Your Ref: ACP-323579-25

Our Ref: SID-OY-2025-021 *(Please quote in all related correspondence)*

Re: Notification under the Planning and Development Act, 2000, as amended.

**Proposed Strategic Infrastructure Development (SID): Proposed Wind Energy Project
- Ballinla Wind Farm within the townlands of Leitrim, Ballyfore Big, Ballyleakin and
Ballina (Geashill By), County Offaly**

Figure 11-5: ZTV Mapping

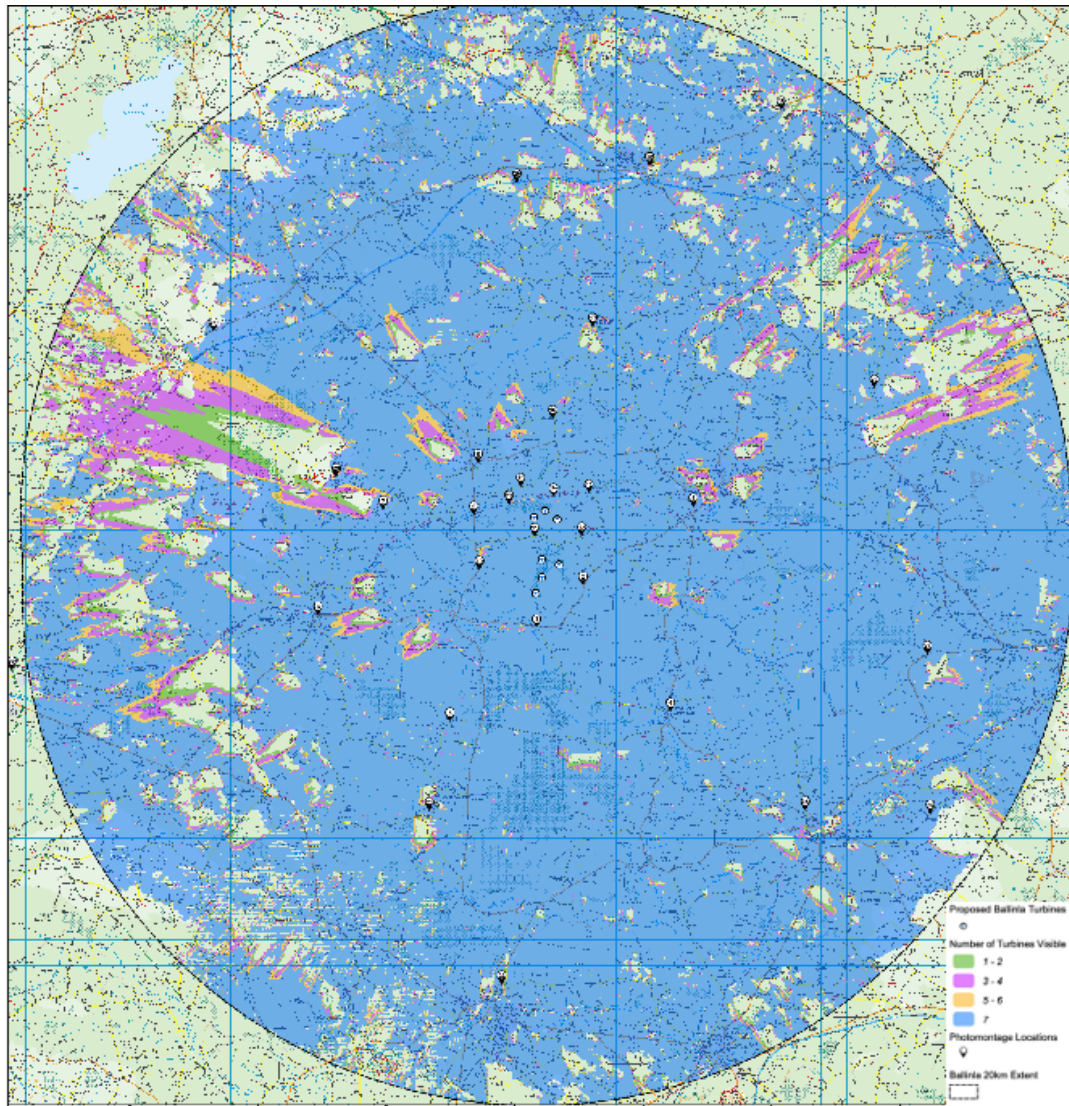
The Zone of Theoretical Visibility (ZTV) prepared for this proposal extends out to 20km from the PDS (EIAR Figure 11-5; Appendix 11-2). While the limitations of ZTV are acknowledged, Section 11.3.4.1 of the EIAR notes that there is a very consistent level of potential visibility out to 5km, with more sporadic visibility only emerging out past 10km (where there is much greater topographic screening of the development). This would suggest a potential for indirect impacts (visual impacts/impacts to setting) could reasonably extend up to 10km from the PDS.

These monuments are subject to statutory protection under Section 14 of the National Monuments Act 1930-2014. Potential for impacts to the setting of Cannakill Deserted Settlement can be discounted, as ZTV mapping indicates that it is in a location where visibility of turbines should be fully screened by natural topography. However, the two other sites are at locations where potentially all turbines could be visible and cumulative impacts to setting could also occur as a result of other proposed/permitted wind farm developments based on the provided ZTV mapping. Clonin Ring-Barrow is particularly vulnerable to impacts on setting as it is located at the top of Clonin Hill, c. 3.5km NNW of the PDS, with extensive views of the surrounding countryside, including of other prehistoric monuments in the general area.
